## KITTTITAS COUNTY COMMUNITY DEVELOPMENT SERVICES

December 11, 2019

Subject: Shoreline Exemption Permit (SX-19-00018) – Critical Area Report

Above: Wetland and stream map of study area.

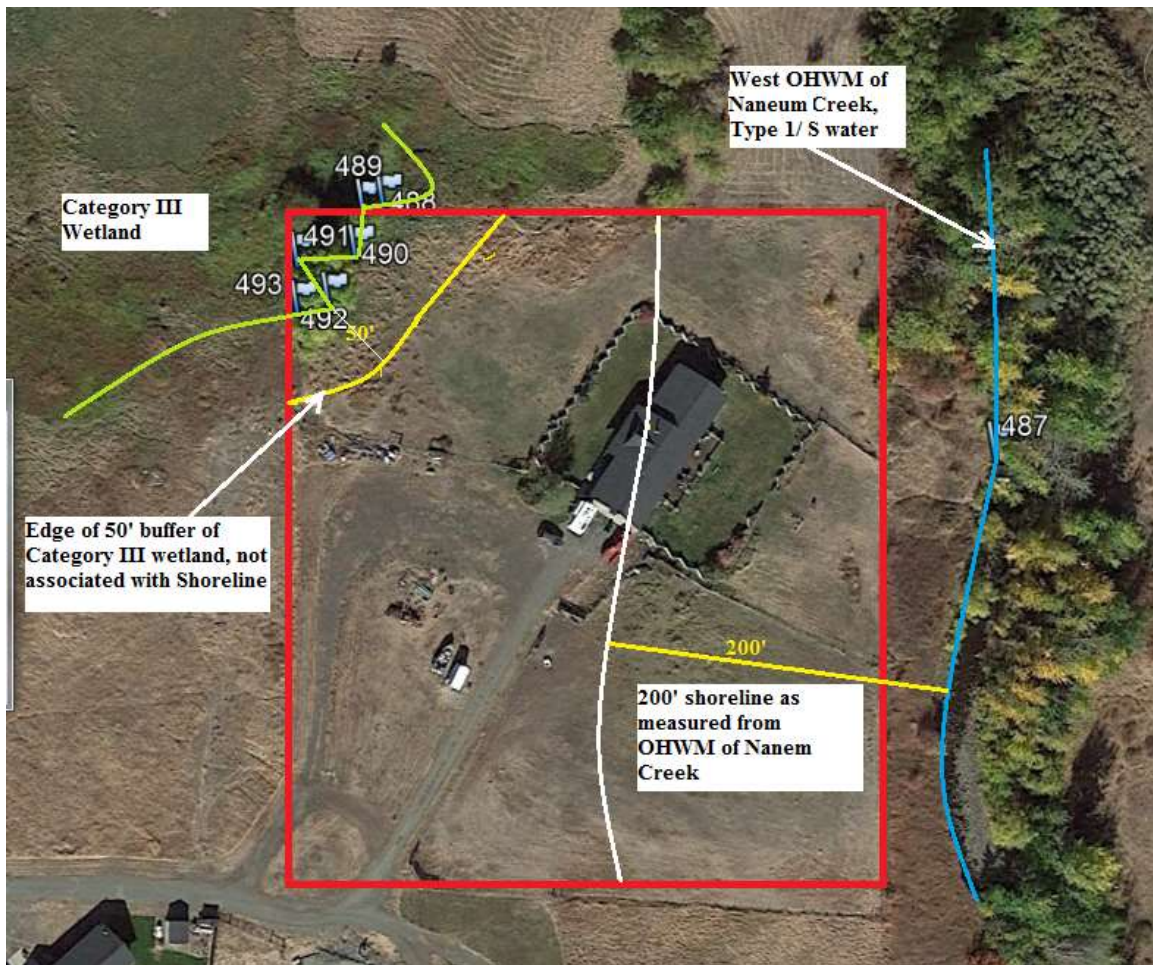
At this time, this proposal is being reviewed under shoreline regulations found in the Kittitas County Shoreline Master Program and Kittitas County Code (KCC) Title 17B – Shorelines. The wetland biologist report identifies the wetland at the northwest corner of the property as a category III wetland. KCC 17B.05.020G Wetlands – buffers, requires a minimum buffer of 75 feet. The report currently shows 50 feet.

Please have the wetland biologist report updated to include the above changes and submit a copy to our office. Once received, we can proceed with processing your shoreline exemption application.
